Reference: Engineering Services
4131 US 421 N.
Lillington, NC 27546
TE&D Project No.: 2301-020954

- 1) Assessment of firewall assembly installed in lieu of the plan specified assembly.

XXX TWO-STORY SHAFT WALL DETAIL
SCALE : 3/4" = 1'-0"

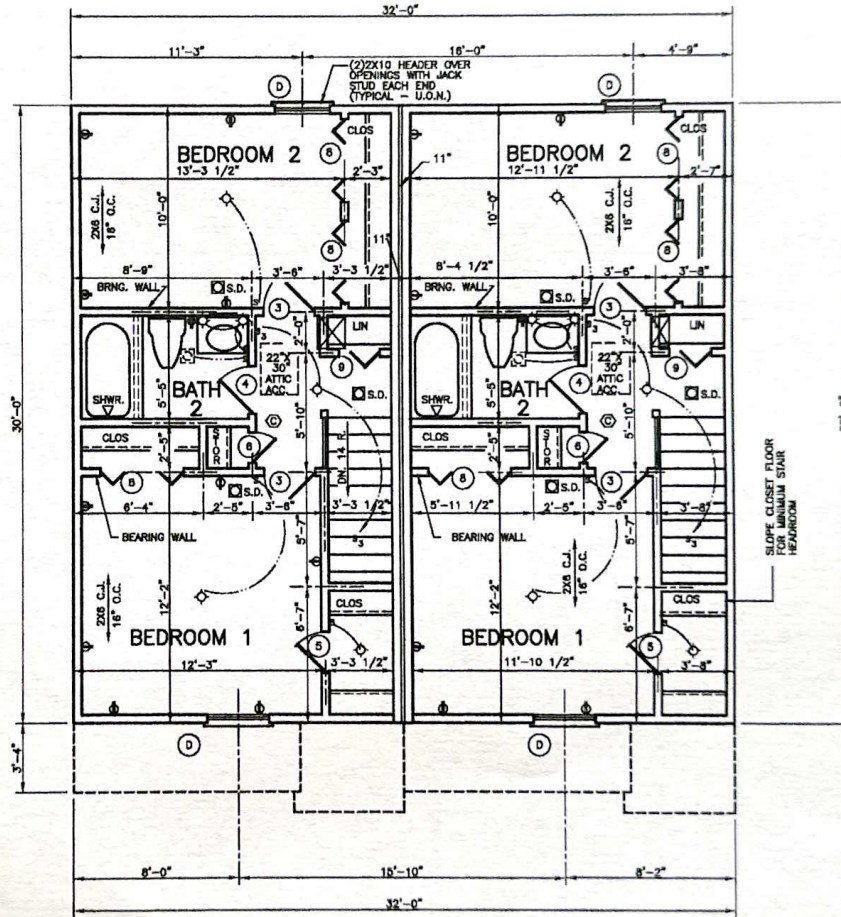
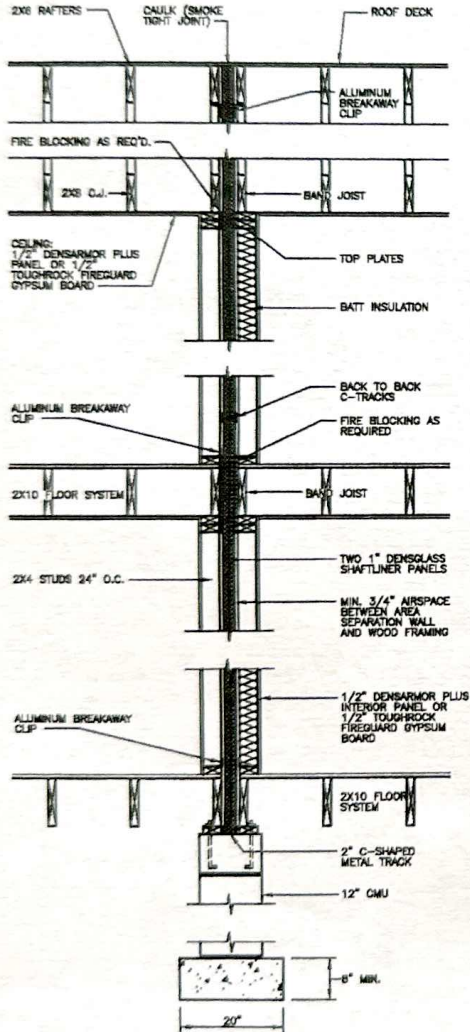
- 1) We observed the firewall was assembled as follows from interior face to interior face: 2 x 4 stud wall framing, 5/8" gypsum panel, 1" - 2" airspace gap, 5/8" gypsum panel, 2 x 4 stud wall framing.

Based on our observations and analysis, TE&D recommends installing an additional layer of 5/8" type X gypsum panels at each side of the firewall assembly. The final assembly is to be as follows from interior face to interior face: 5/8" type X gypsum panel, 2 x 4 stud wall framing, 5/8" gypsum panel, 1" - 2" airspace gap, 5/8" gypsum panel, 2 x 4 stud wall framing, 5/8" type X gypsum panel. See attached detail.

Upon completion, the firewall assembly will meet the 1-hour assembly requirement of the 2018 North Carolina Residential Building Code. We appreciate being able to assist you during this phase of the project. If you need further assistance or require additional information, please do not hesitate to contact us.
